Application by Oxfordshire Railfreight Limited (the Applicant) for an Order granting Development Consent for the Oxfordshire Strategic Rail Freight Interchange (the Proposed Development)

Thank you for consulting Network Rail on the Scoping Report relating to the abovementioned development proposal. We are aware of this proposal and are engaged in feasibility work regarding the proposed rail connection.

Having reviewed the information supplied in the Scoping Report, we request that the scope of the EIA is broadened to also include the following matters:

**BRIDGE PLANS  
ARDLEY ROAD / B430  
ARDLEY BYPASS  
OVERBRIDGE (BRIDGE 16)**

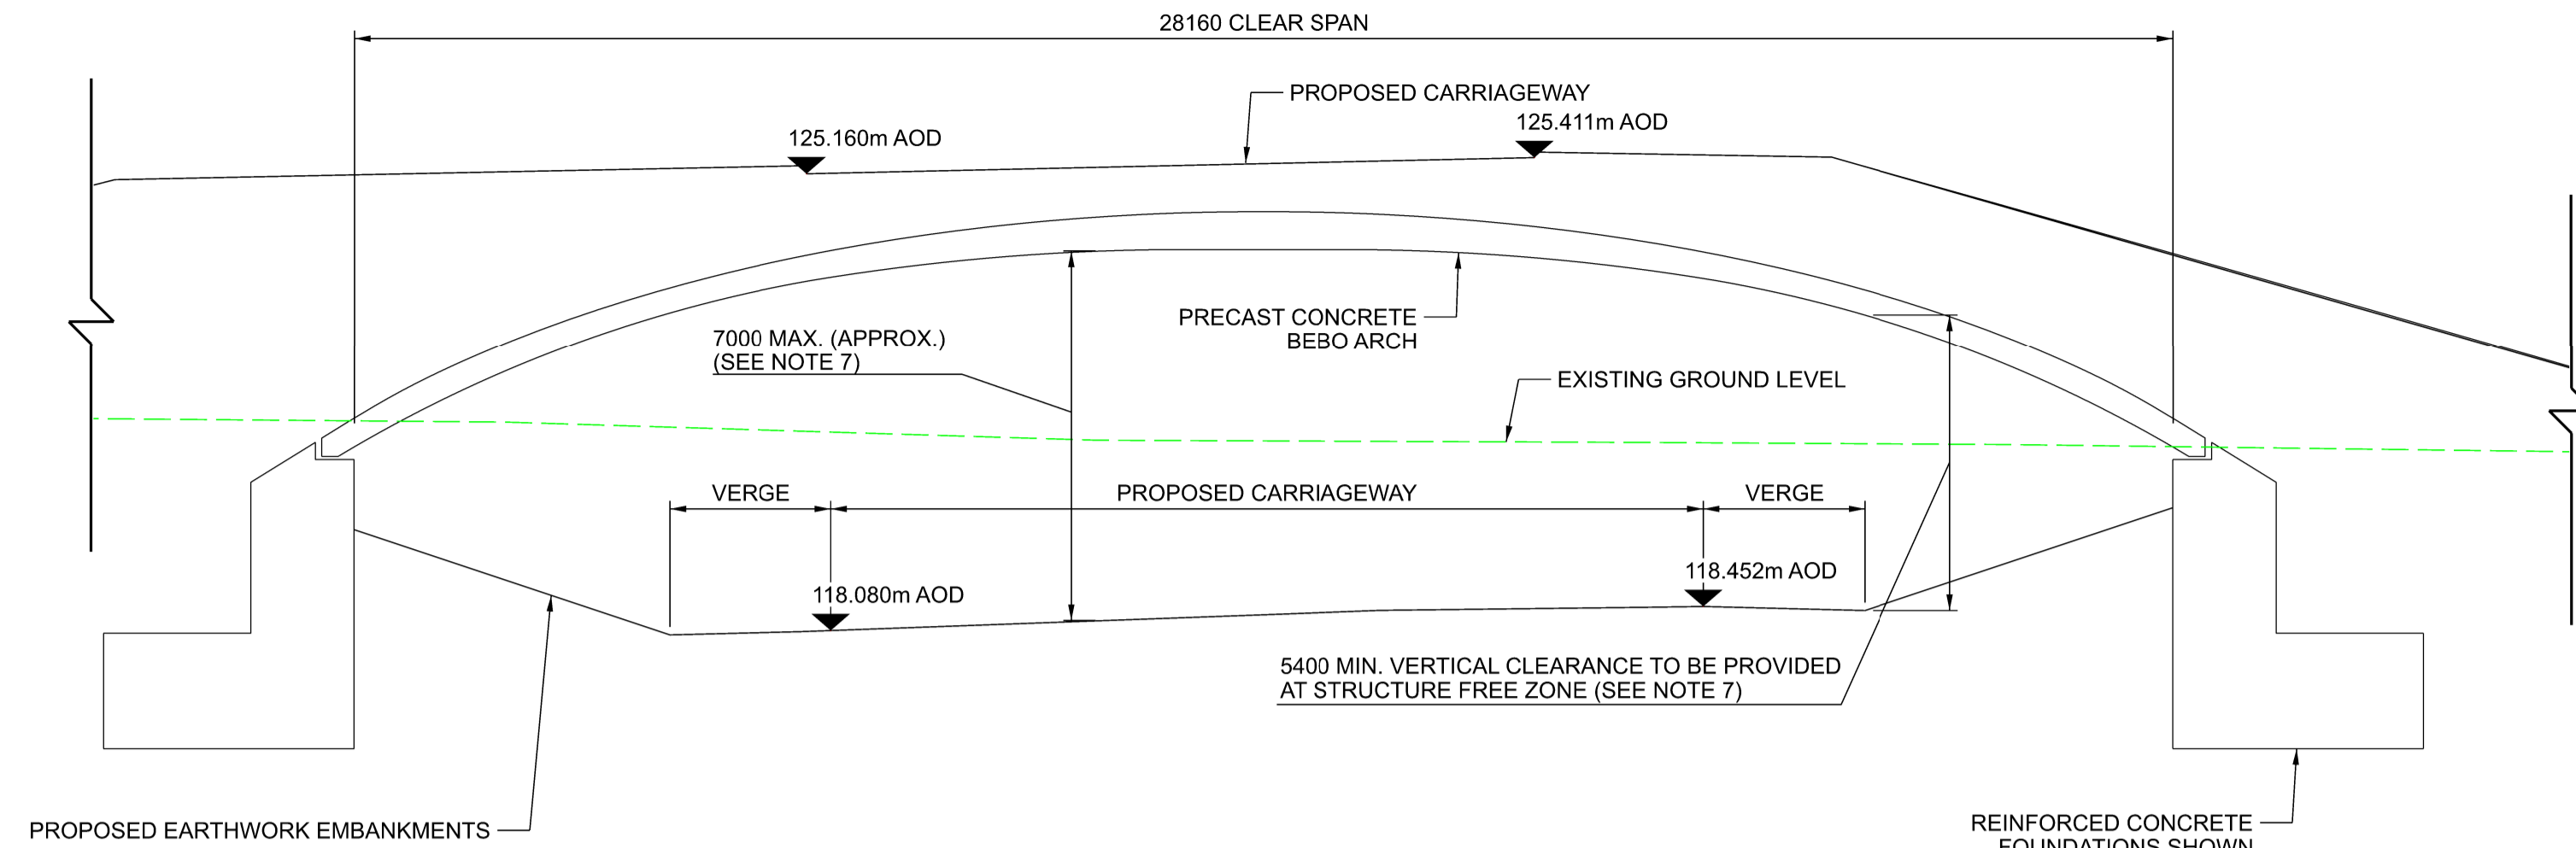
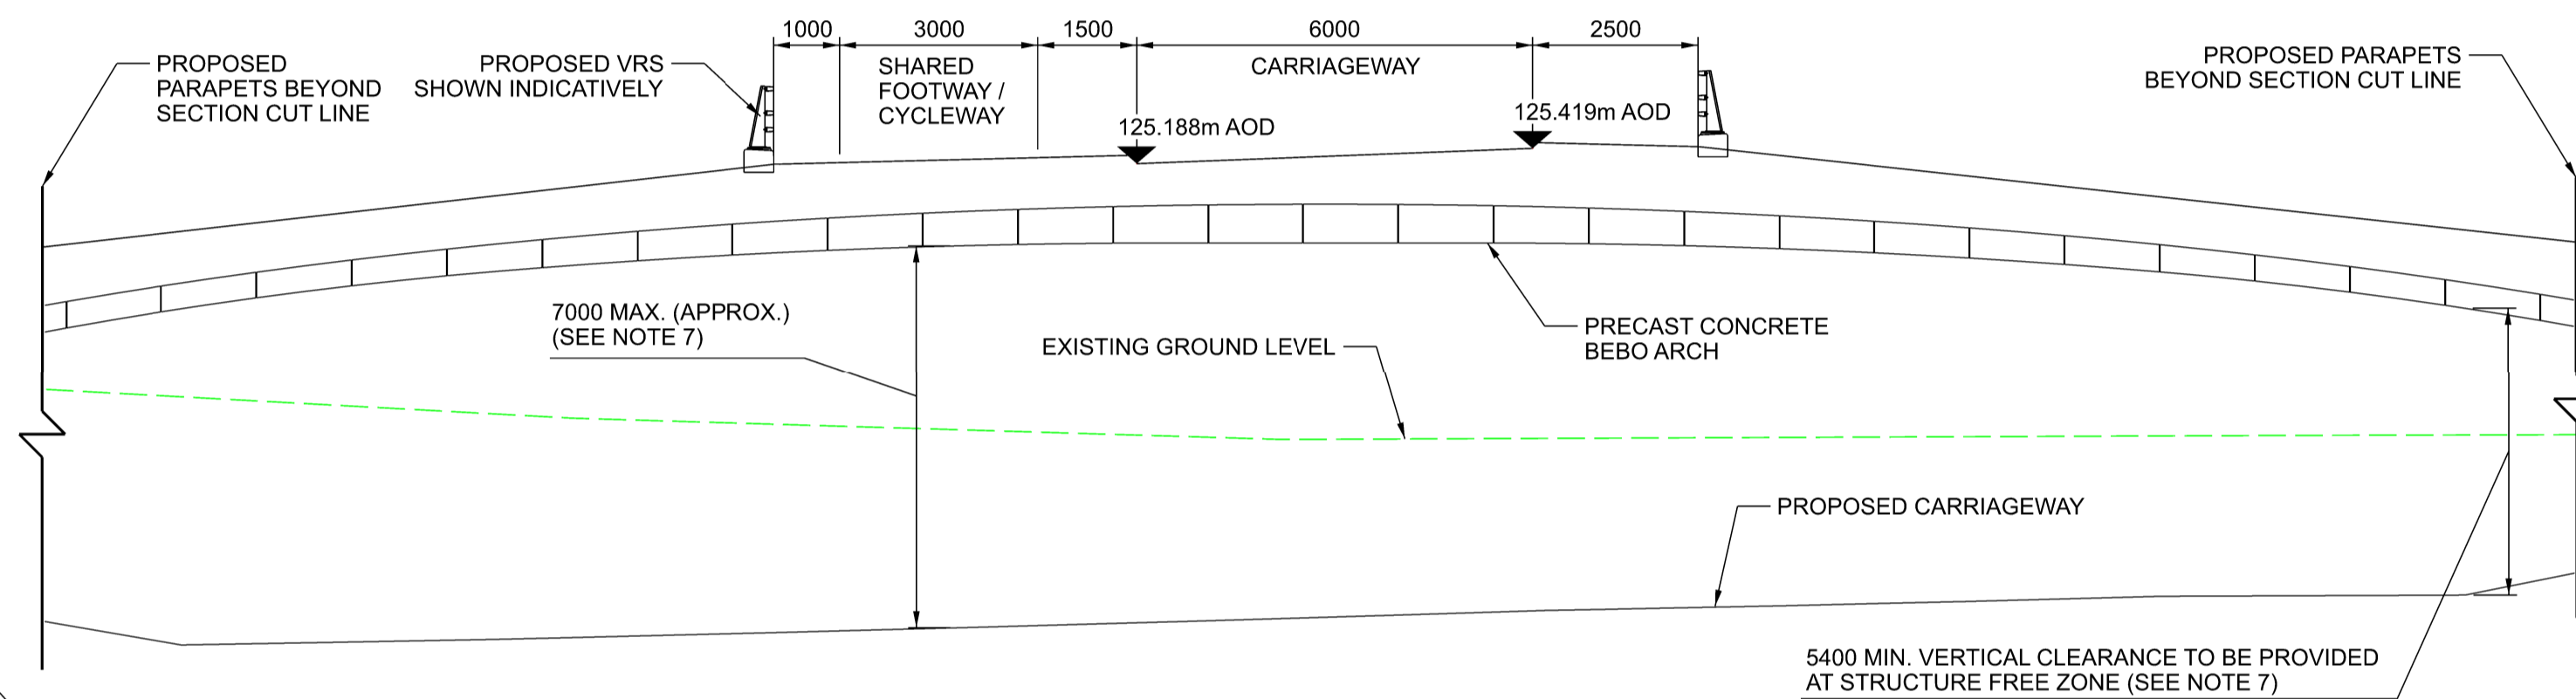
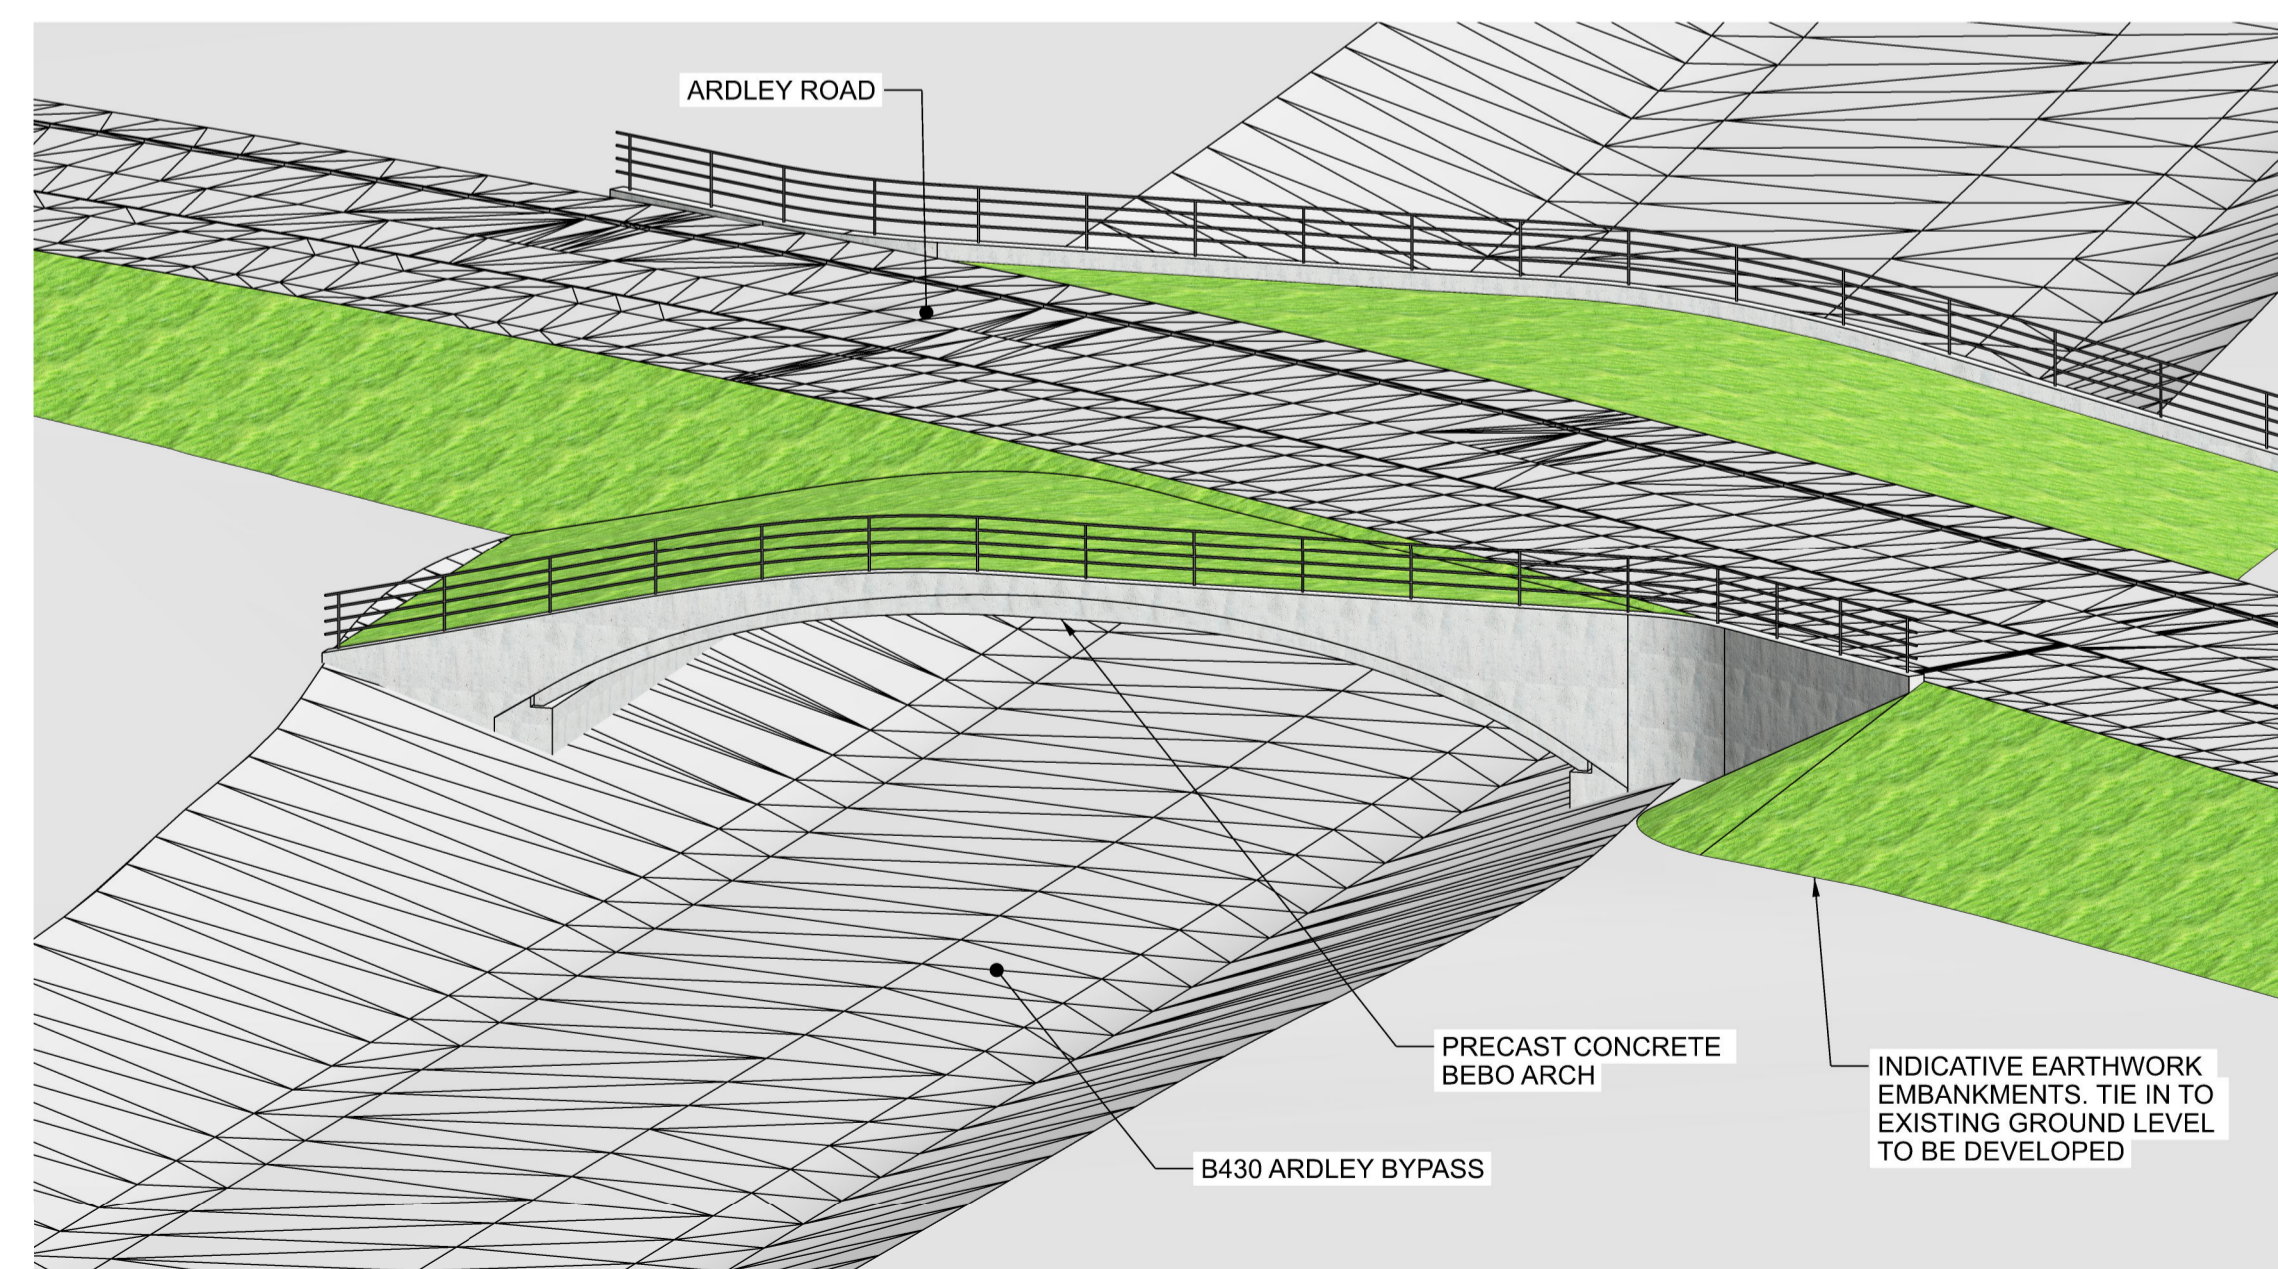
The impact of construction and operational traffic on existing bridges over the railway line will also need to be assessed in terms of their suitability to carry heavy vehicles, or an increase in the volume of such. These bridges include (but may not be limited to): B430, Somerton Road and the unnamed spur road off Somerton Road, Raghouse Lane and the proposed diversion of a PROW over the existing private accommodation bridge accessed via the Ardley Field Household Waste and Recycling Centre. The construction management plan and operational delivery plan should include all necessary mitigation.
